Your Ref: OWPC20981
Our Ref: EP/166/18/HH 13-11-2018
Please ask for:
Zac Denton

Erection of a two storey rear extension, second storey enlargement of side dormer and conversion of garage to study including demolition of existing conservatory
100 Sea Road East Preston

Thank you for your internet representation made on 2nd January 2019 which has been recorded as '**an objection**' with the comments as follows:

PROPOSED FLOOR
PLANS 1:50

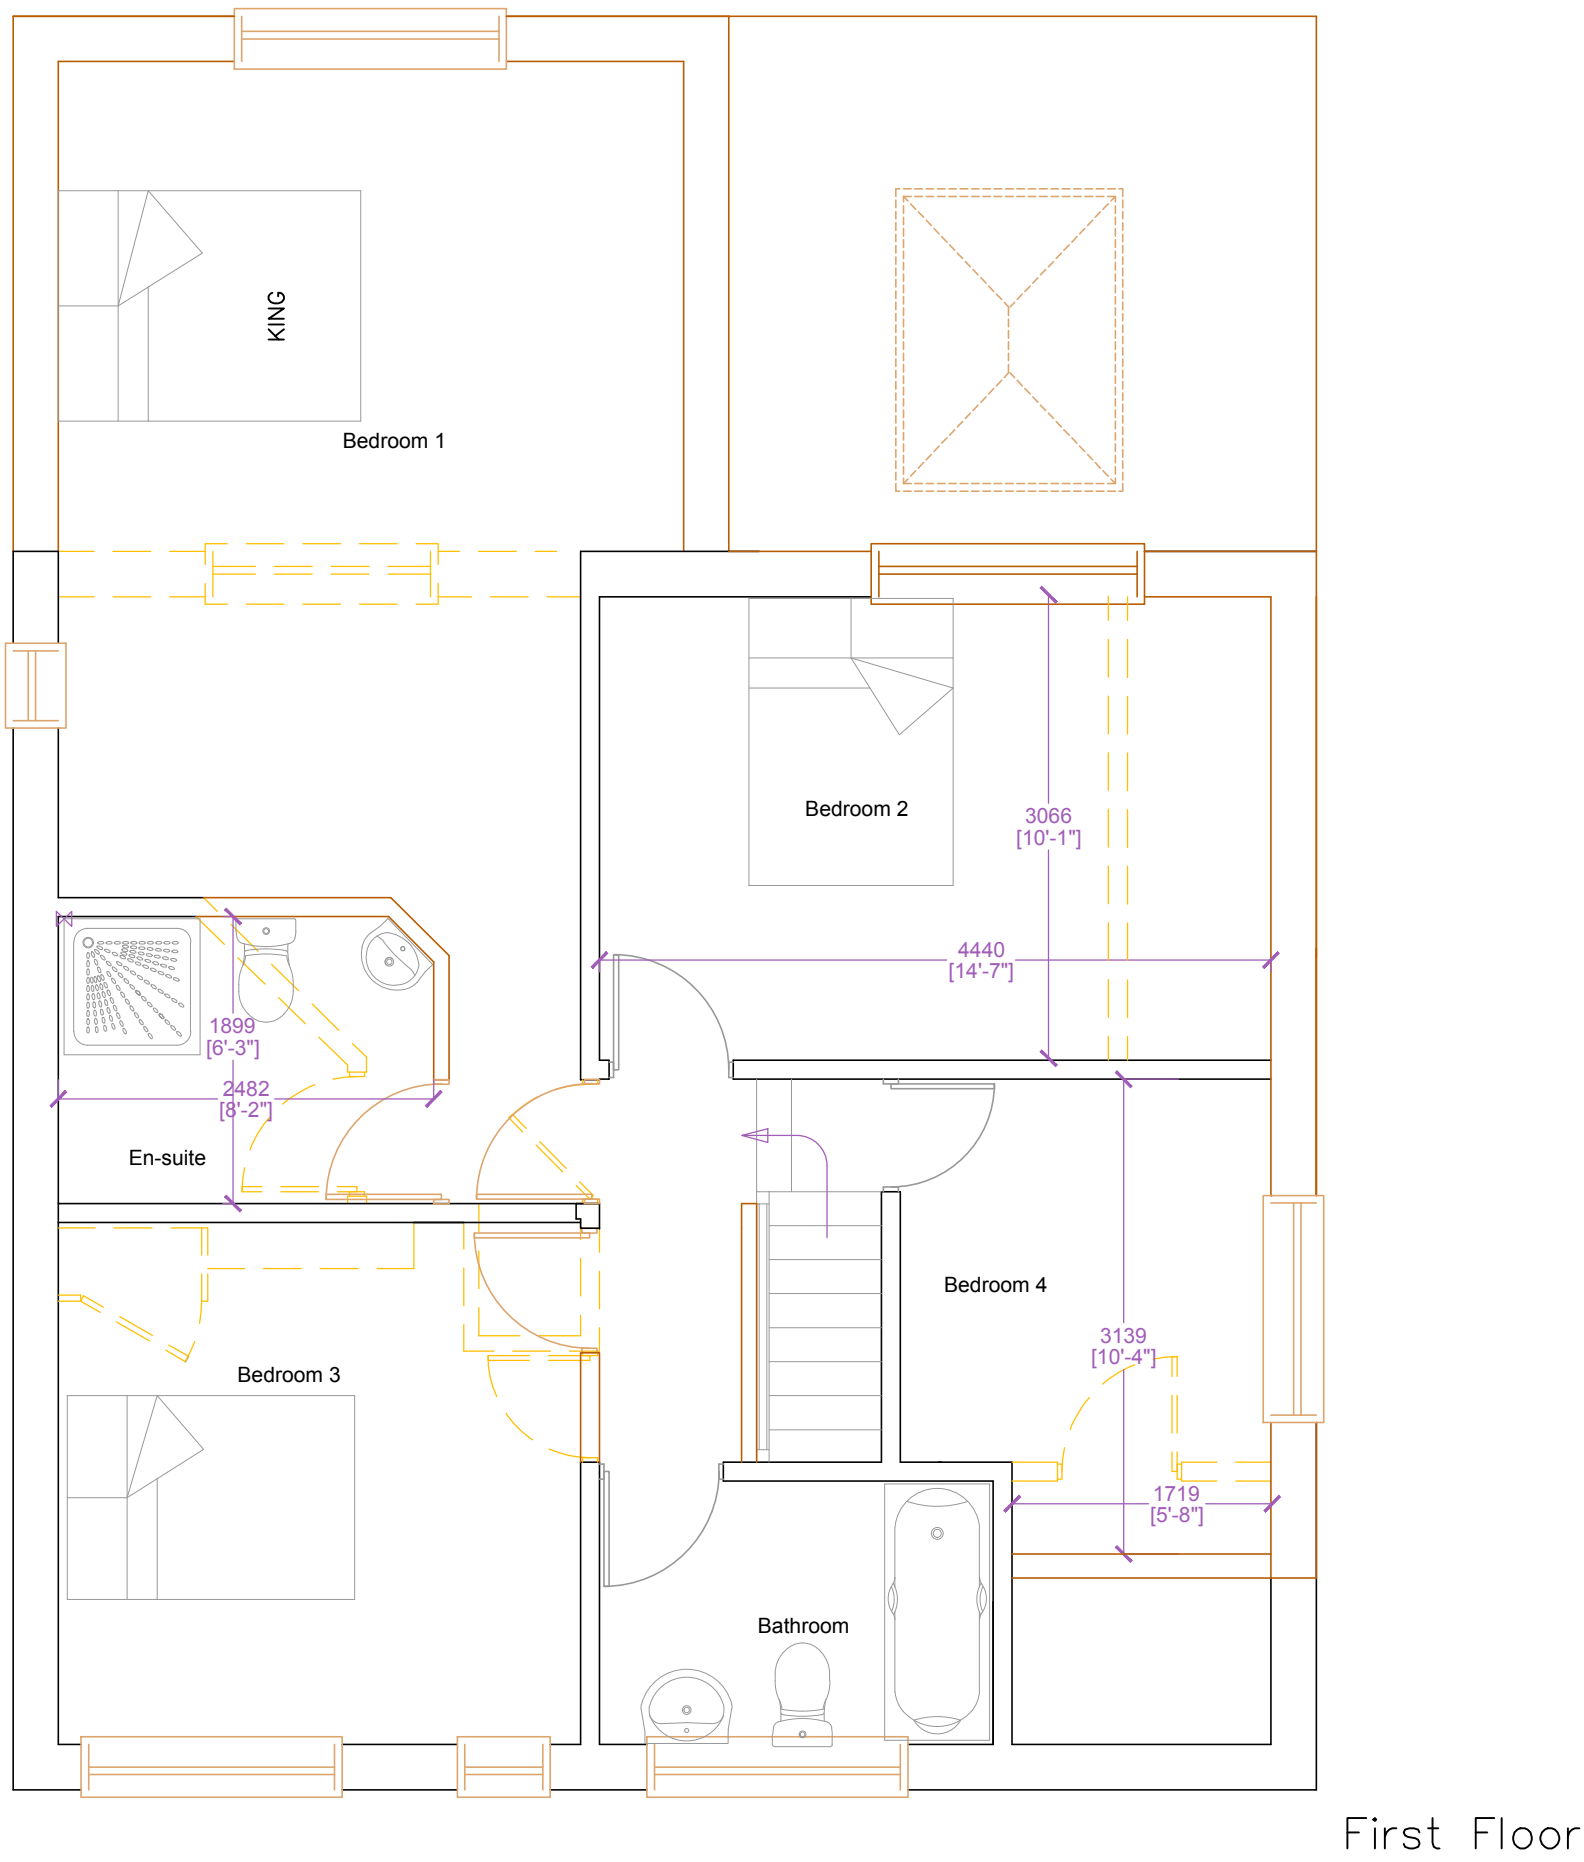
A two storey develop outside the envelope of the existing property is an over-development of the site. It will be far too overbearing for neighbouring properties in particular 102 Sea Road. The council has continually informed residents of Sea Road that any size of 2 storey extension would be out of the question due to their overbearing nature and suitability. We were informed of this when we had a discussion about extending our property where we were told that two-storey extensions at the back of properties would be refused. Support to the application would set a dangerous precedent for the street and is also not in line with the Neighbourhood Plan and the East Preston Conservation Society.
